Central Coast Regional Cancer Centre Holden Street, Gosford

February 2011

Major Project MP 10_0173
Preferred Project Report

TITLE: DETAILED SITE PLAN
 SCALE: 1 : 200
 DATE:

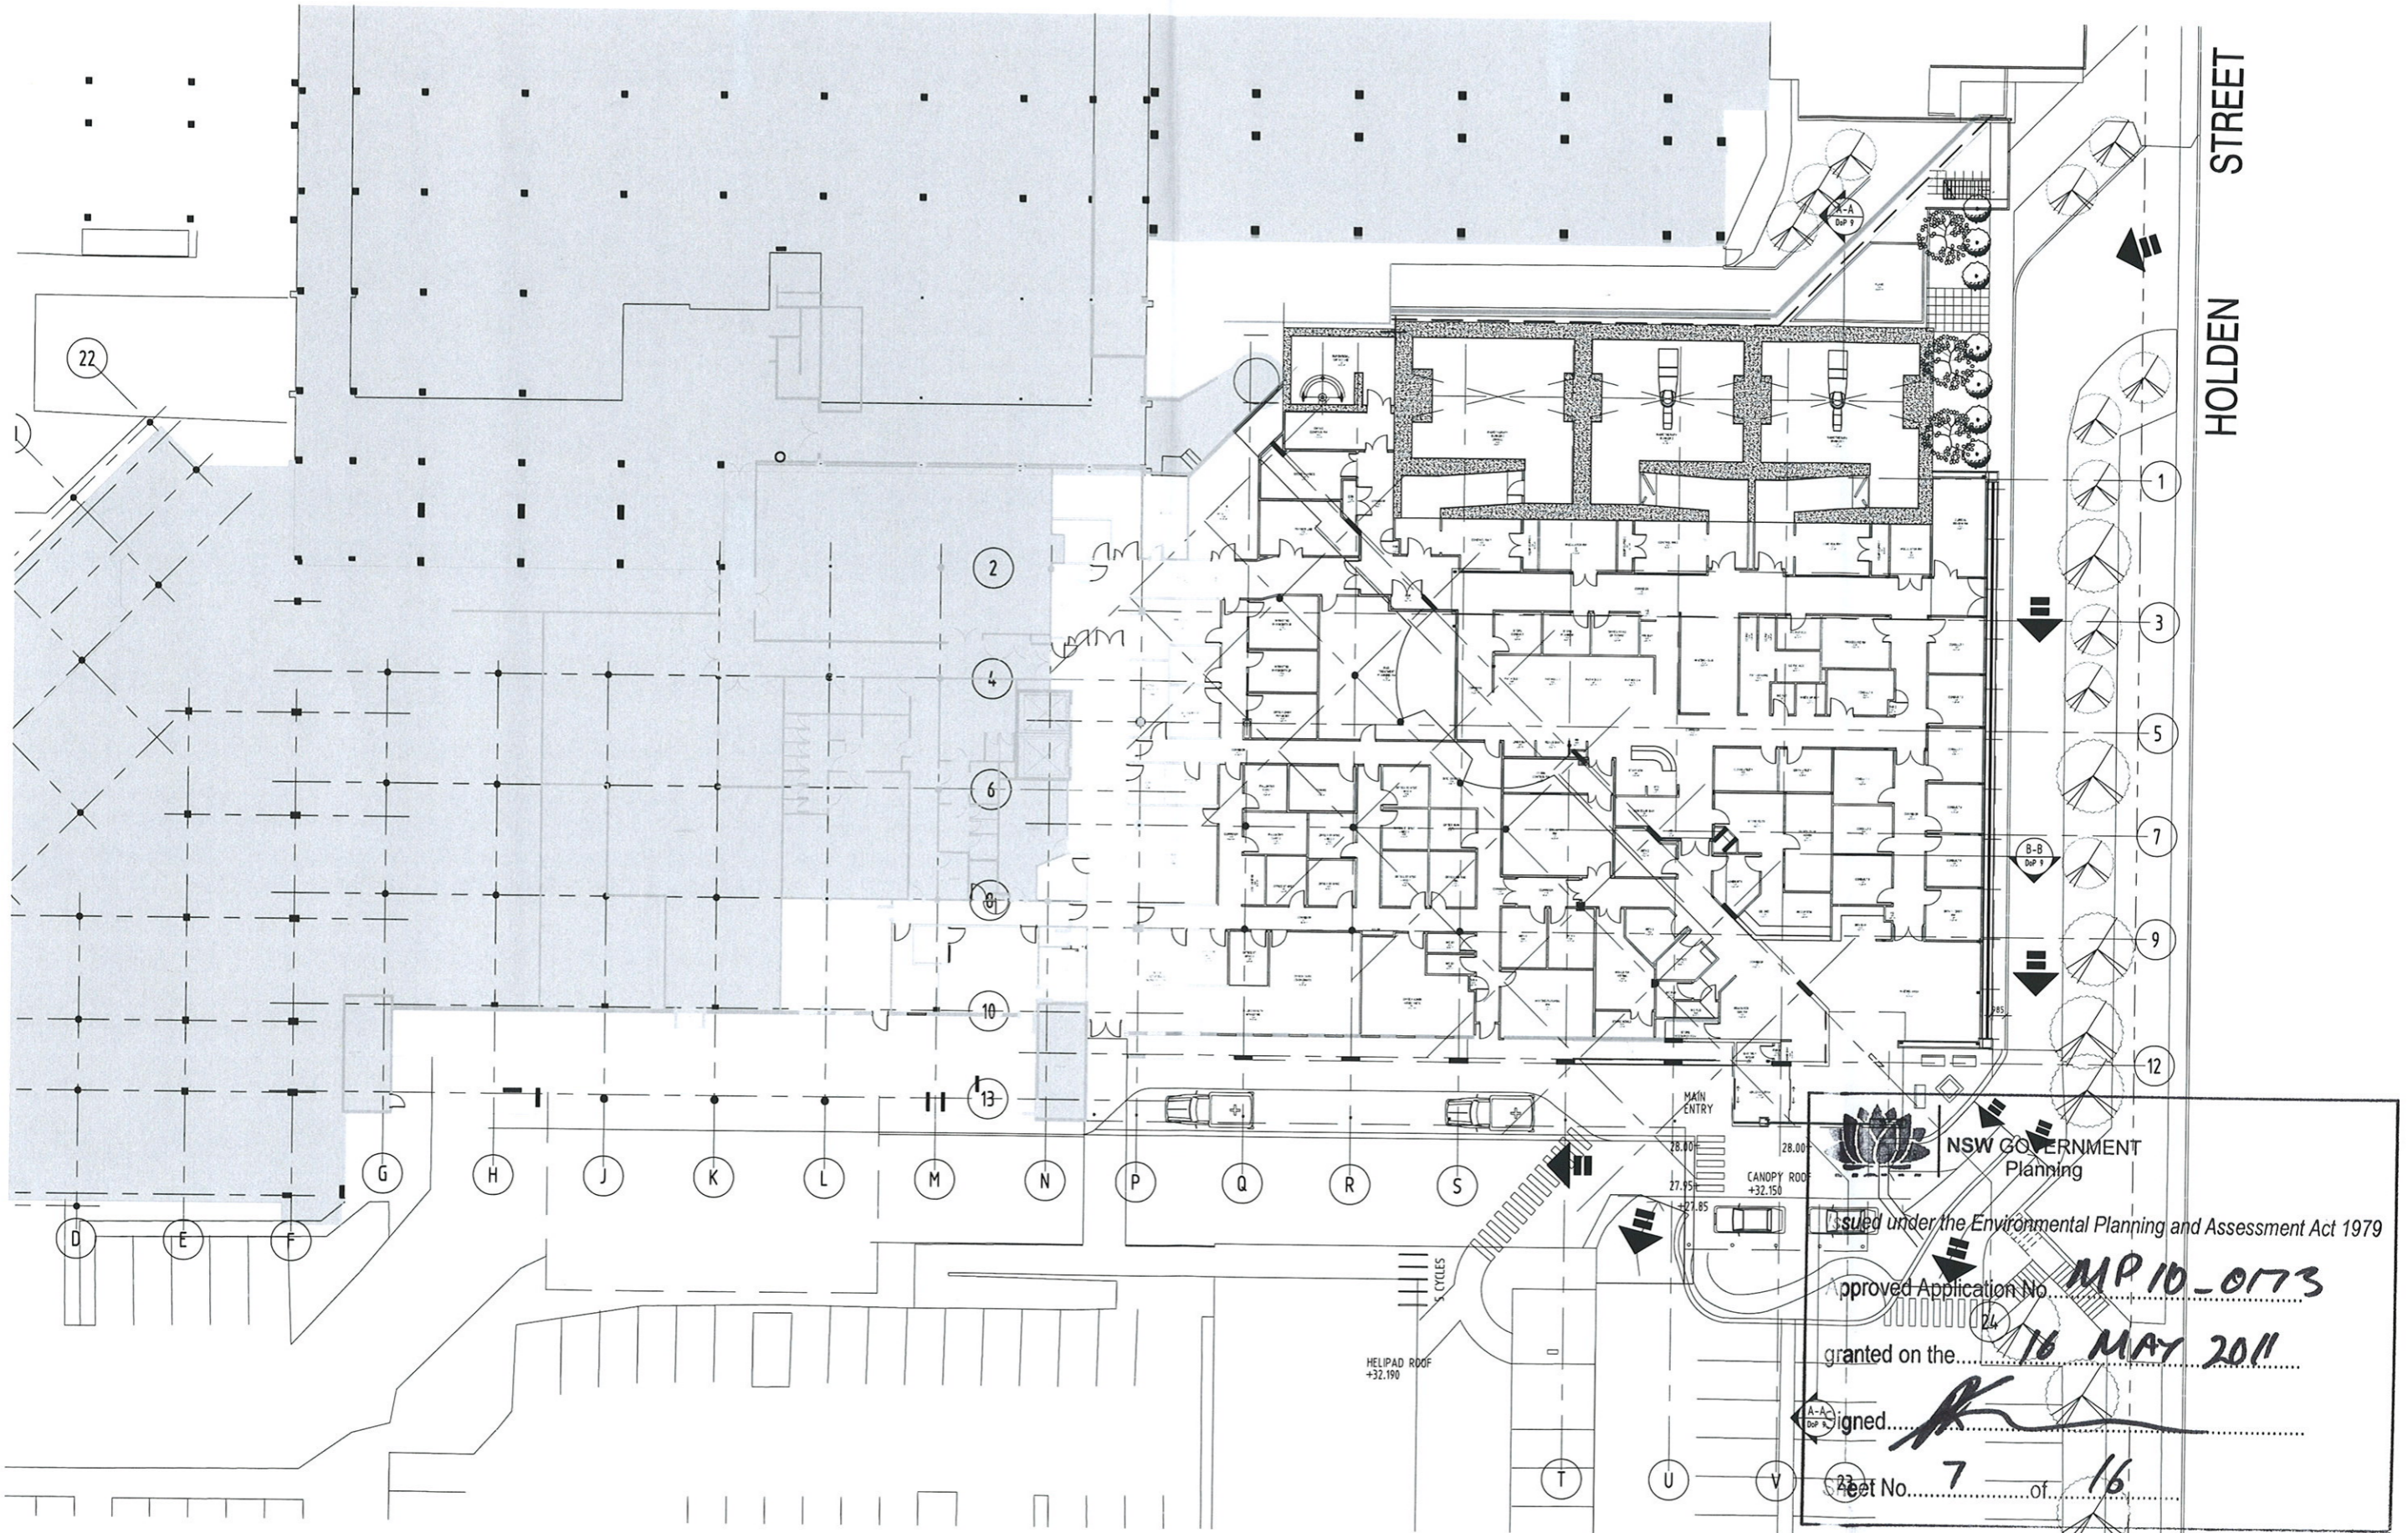
The Department's letter also identified a number of concerns relating to the proposed car parking arrangements, impacts associated with the development of the proposed four new car parks, and clarification of the total number of new car parking spaces to be provided, which differ in the Environmental Assessment and the Traffic and Transport Report prepared by SKM dated 16 November 2010. The Department requested a response to these concerns, refer **Table 2** below.

A new five-bike rack is proposed as shown on the amended detailed site plan DoP06 at **Appendix A**. Refer to

NO. **DoP 14** AMD. **D**

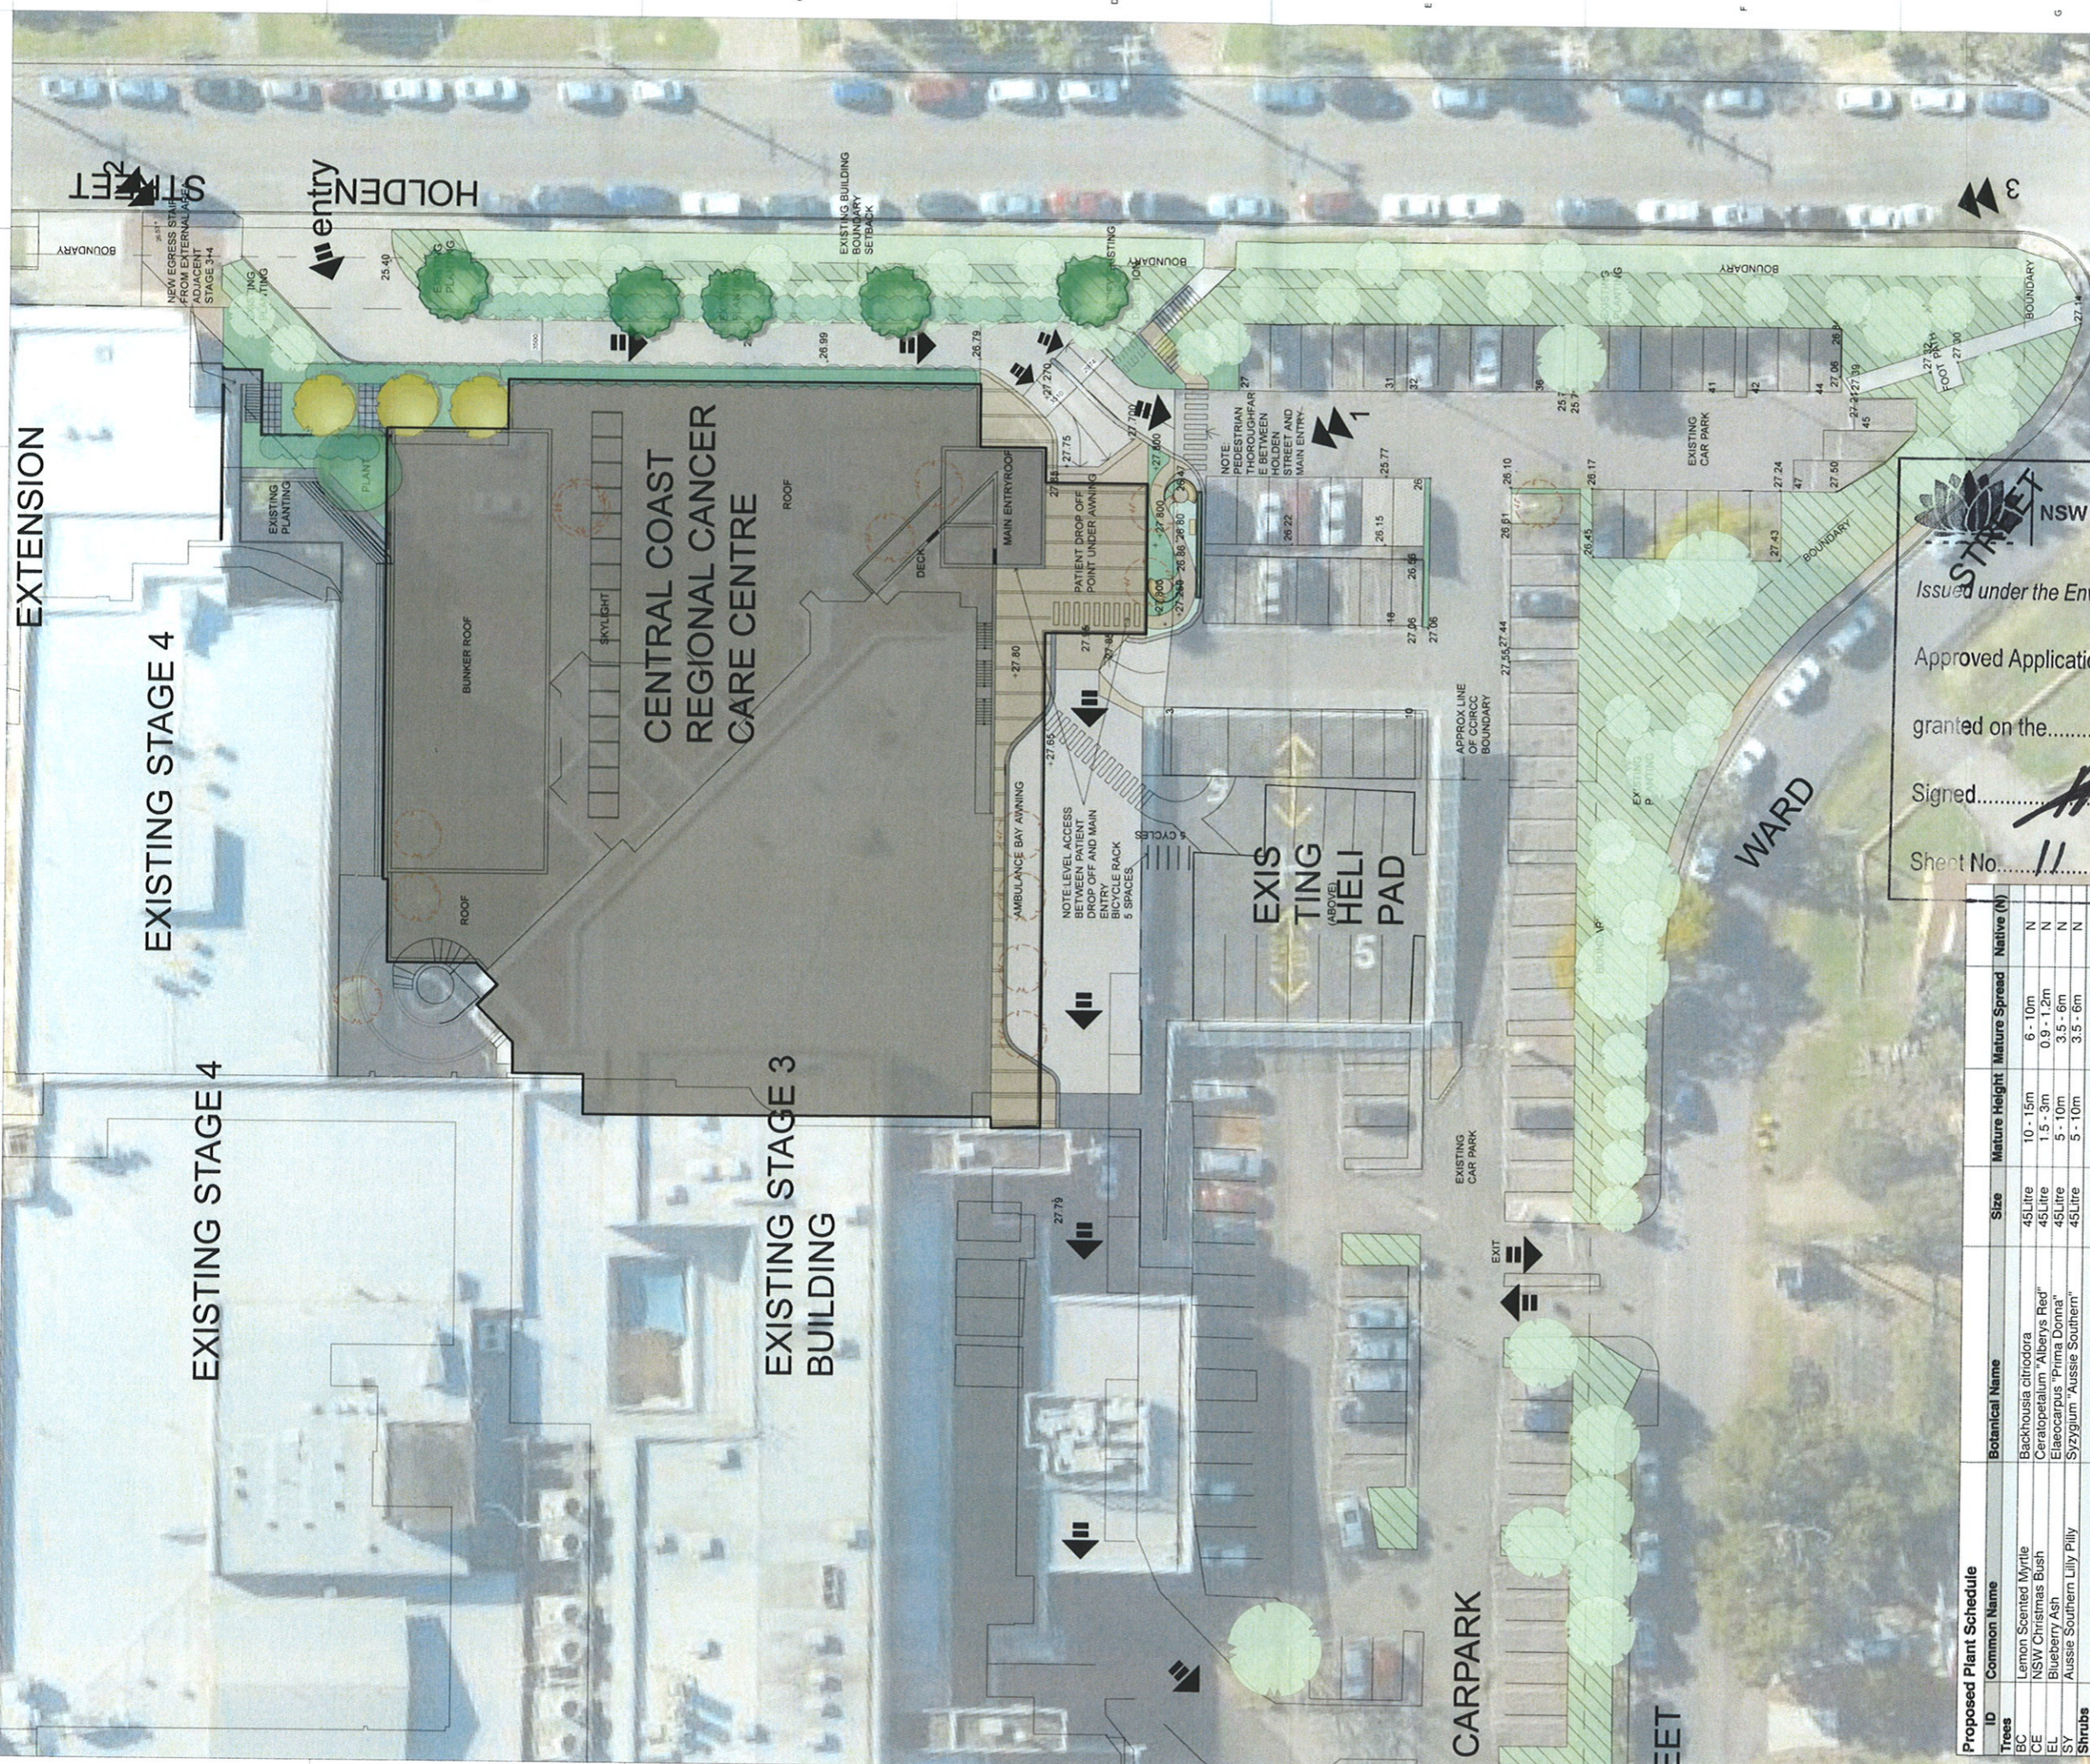
The project team of specialist consultants have assisted in preparing responses to the key issues raised in submissions. Relevant specialist studies and documentation prepared for the exhibited Environmental Assessment have been reviewed and updated to reflect the Preferred Project including the Traffic Report (refer **Appendix B**), the architectural drawings (refer **Appendix A**) and the landscape plan (refer DoP14 at **Appendix A**).

The Environmental Assessment includes a Landscape Plan which demonstrates the landscaping proposed for the cancer centre. The proposed landscape design will change to incorporate a new area of seating and landscaping for visitors close from the Regional Cancer Centre entrance (refer landscape plan DoP14 at **Appendix A**).

BEANE STREET CARPARK - TOTAL NUMBER OF NEW SPACES - 8 NOT TO SCALE

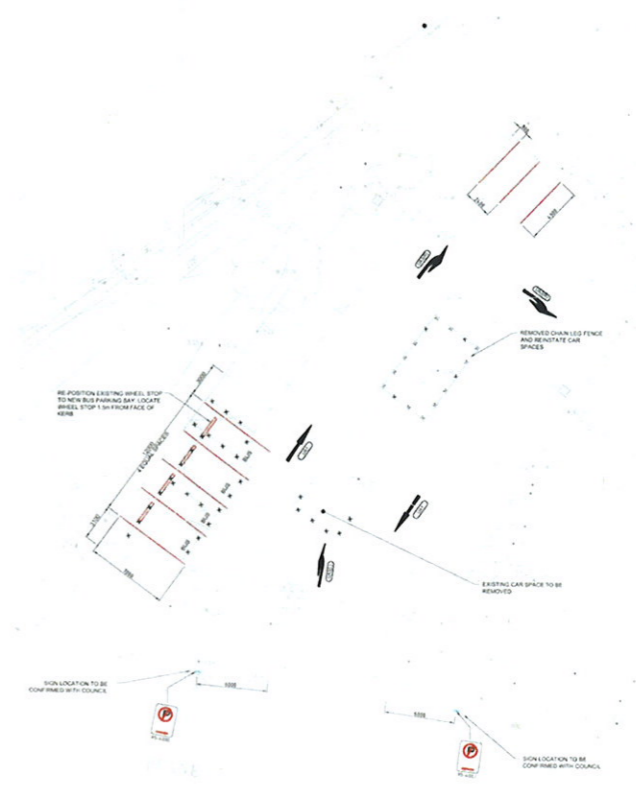
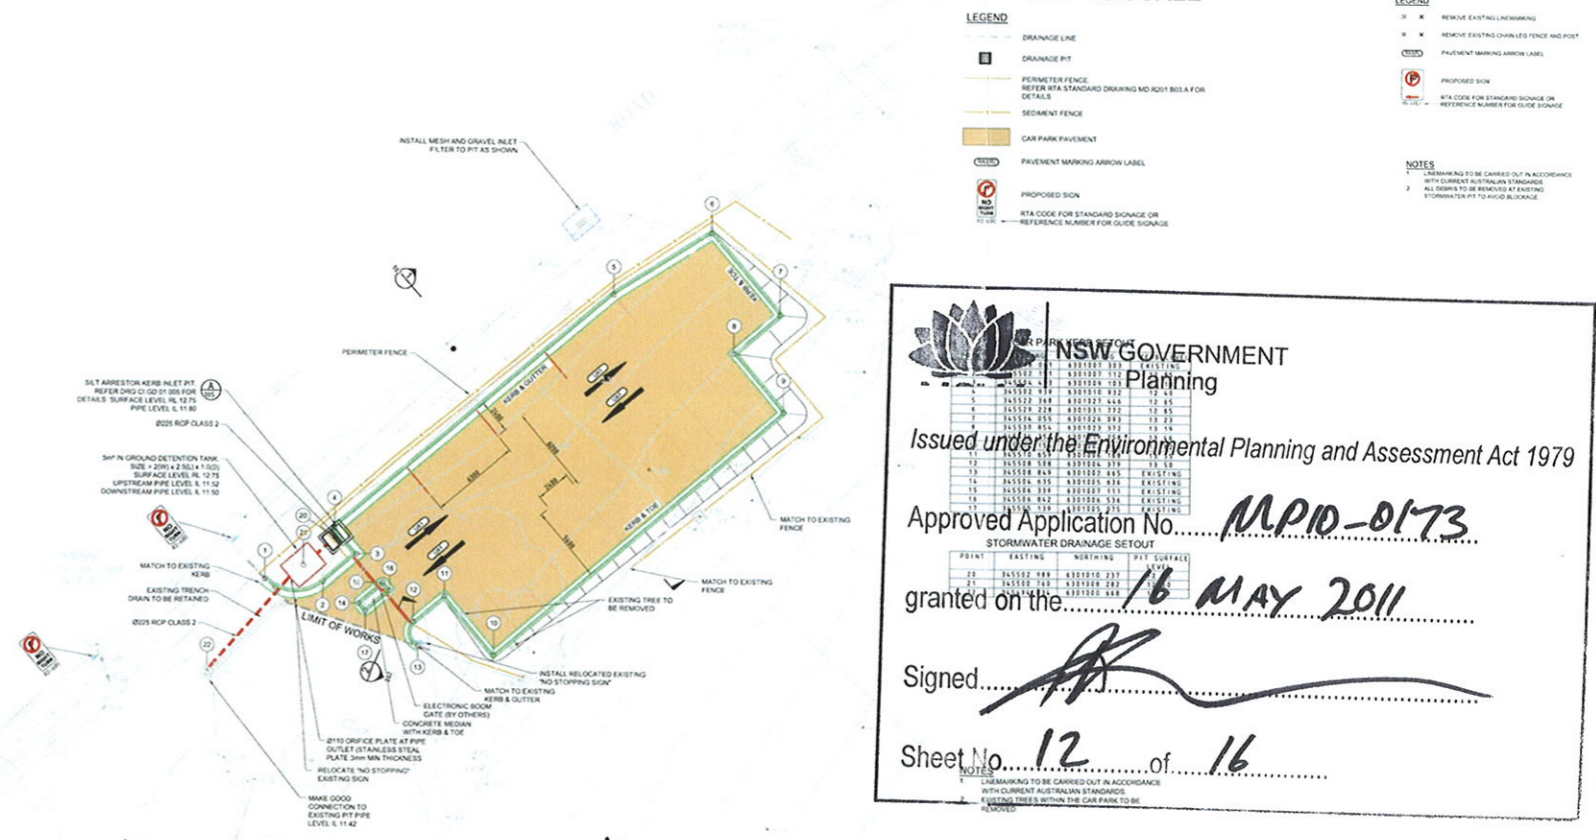
The submitted Traffic and Transport Report, prepared by SKM, dated 16 November 2010, details different figures for the total number of new car parking spaces to be provided, which will require clarification.	The correct total number of new car parking spaces to be provided as amended by the Preferred Project is 54. Further investigations have revealed that it is possible to provide 8 additional spaces within the Beane Street car park by changing the line-marking, without the need to expand the car park. The updated Traffic and Transport Report at Appendix B details these changes.

- Cnr of Beane and Racecourse Road to provide 6 additional spaces – this is increased to 8 additional spaces in the Preferred Project;
- Hospital Road to provide 11 additional spaces;
- Fleet car park area to provide 15 additional spaces.
